# Response to LB Hillingdon Comments

Title: Hayes Park West – Response to LB Hillingdon Comments

1. This note has been prepared by Iceni Projects on behalf of Shall Do Hayes Developments Ltd (The Applicant), as a response to comments received on the Hayes Park West Application. Comments were dated 30<sup>th</sup> January 2026.
2. The table below highlights the comments made by LB Hillingdon (LBH) in the left-hand column with the Iceni response on behalf of the Applicant in the right-hand column.
3. Should there be a need for further discussions, Iceni and the Applicant team would welcome the chance to discuss this further but believes that the information below and the ATZ assessment (to follow in due course) should satisfy the remaining comments.

| DRAWN BY | CHECKED BY | APPROVED BY |
|-------------|-------------|-------------|
| 1001132 | 06.2 | - |

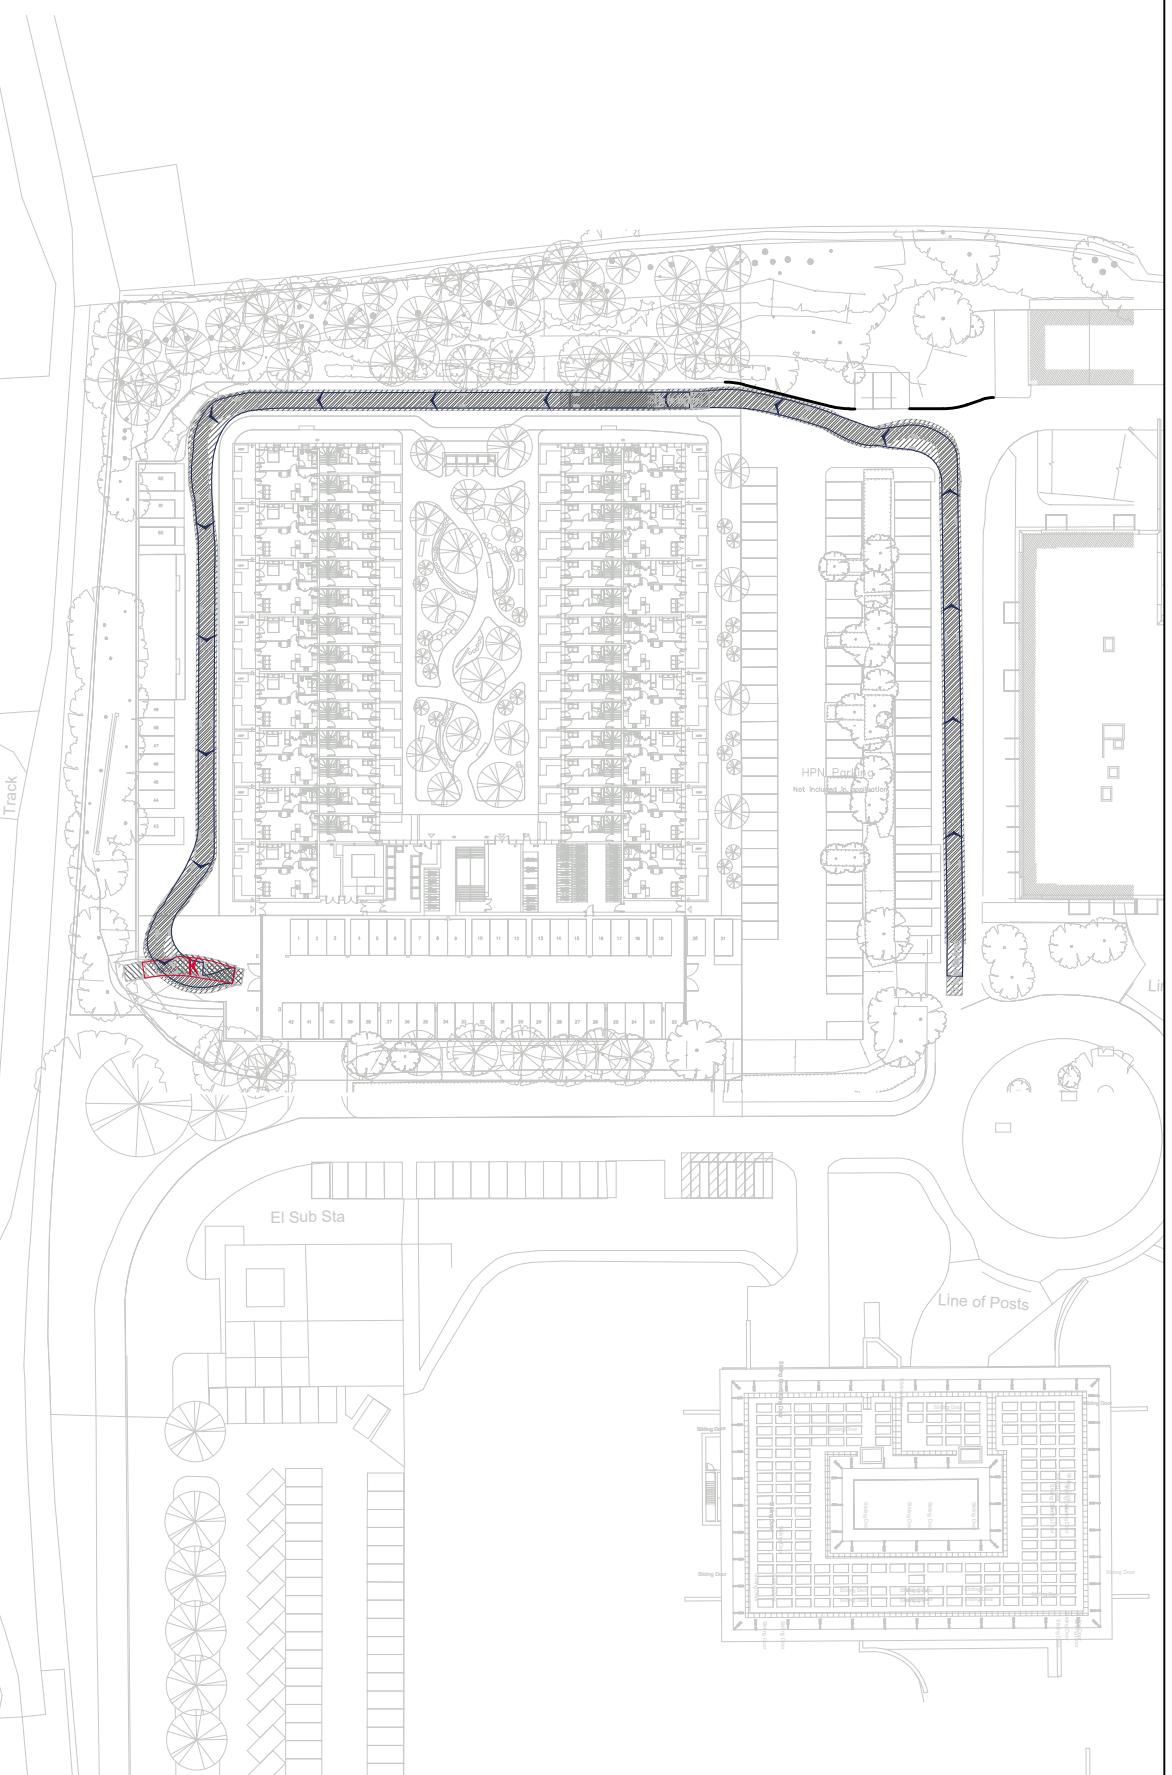
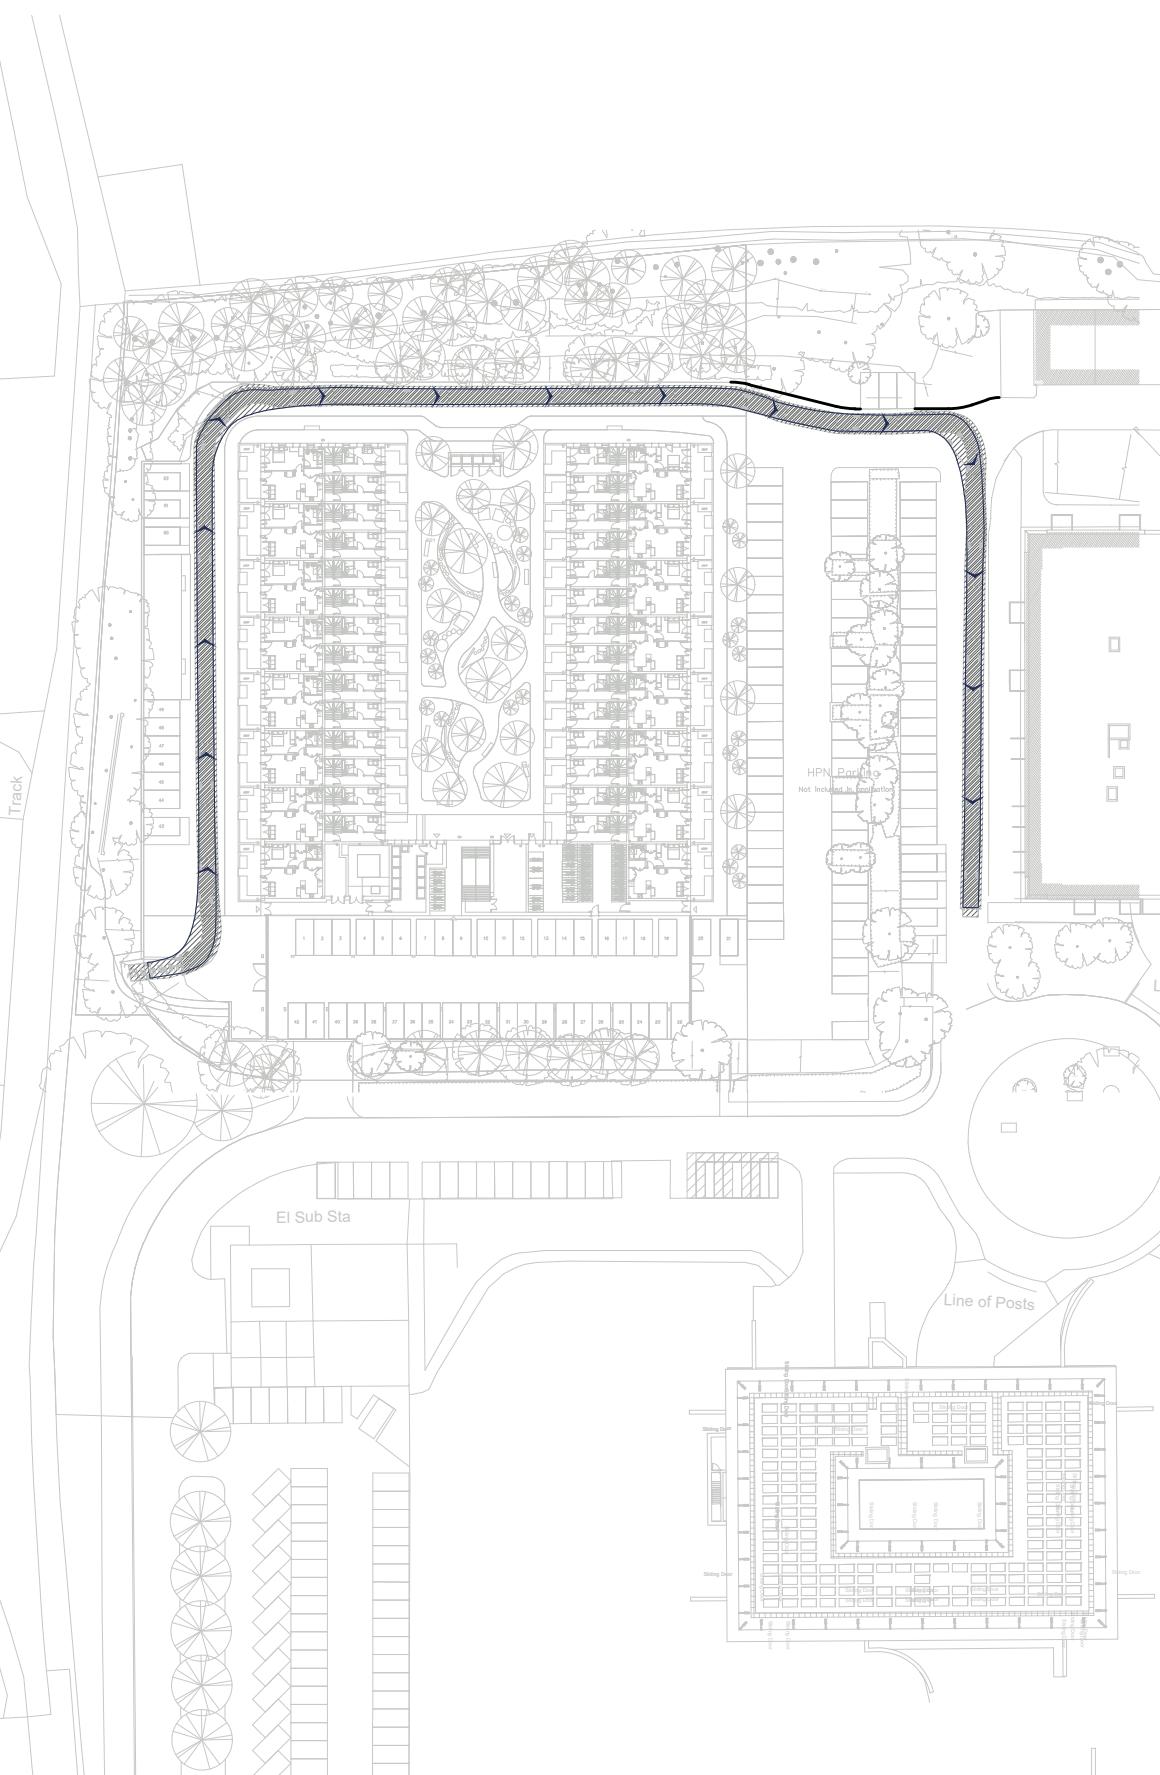
<b>Delivery and Servicing Plan</b>	
<p>The Highway Authority has reviewed the Delivery and Servicing Plan October 2025 and found that Appendix 2A does not include drawing I0001132_06.2, the applicant has therefore failed to show that the largest vehicle expected to visit the site could satisfactorily manoeuvre within the development without presenting a road safety risk to other road users, residents or their visitors. Whilst such drawings have been provided with other documents, they must be included in the Delivery and Servicing Plan as they are referred to in the main text.</p>	<p>Iceni have reviewed the document initially submitted and Drawing I0001132_06.2 is the final drawing included within Appendix A2. Therefore, it is considered that this comment has been addressed.</p>
<b>Outline Construction Traffic Management Plan</b>	
<p>An Outline Construction Traffic Management Plan has also been submitted as part of this application. As the main contractor has not yet been appointed, the amount of information that the Plan contains is limited.</p> <p>The applicant reports that construction vehicles travelling to and from the site would attempt to use the Strategic Road Network wherever possible and where it needs to deviate from this 'A' roads would be used as much as possible. Access to the site would be from the A4020, into Hayes End Road and then along Mead House Lane.</p> <p>The applicant reports that there "will be no separate parking provided for construction workers and therefore they are expected to arrive on foot, cycle, bus or underground". The applicant goes on to explain in the Outline Construction Traffic Management Plan that this will be achieved by the appointed Contractor informing their staff how it is possible to travel to the site by means other than the driver only private car, it is mentioned that public transport maps and timetables would be provided. The Highway Authority does not consider that these measures alone would achieve a modal shift in favour of sustainable transport and in the absence of on-plot parking for the construction workforce may result in injudicious parking on plot or parking displacement on the surrounding streets. This raises a Highway objection though this could be</p>	<p>Iceni notes the concern and will include any final details on employee parking within the final version of the CTMP as requested. This will include further measures to encourage the use of public transport (carrot) and to discourage the use of any onsite parking provided (the stick) but being mindful that some on site parking may be required.</p>
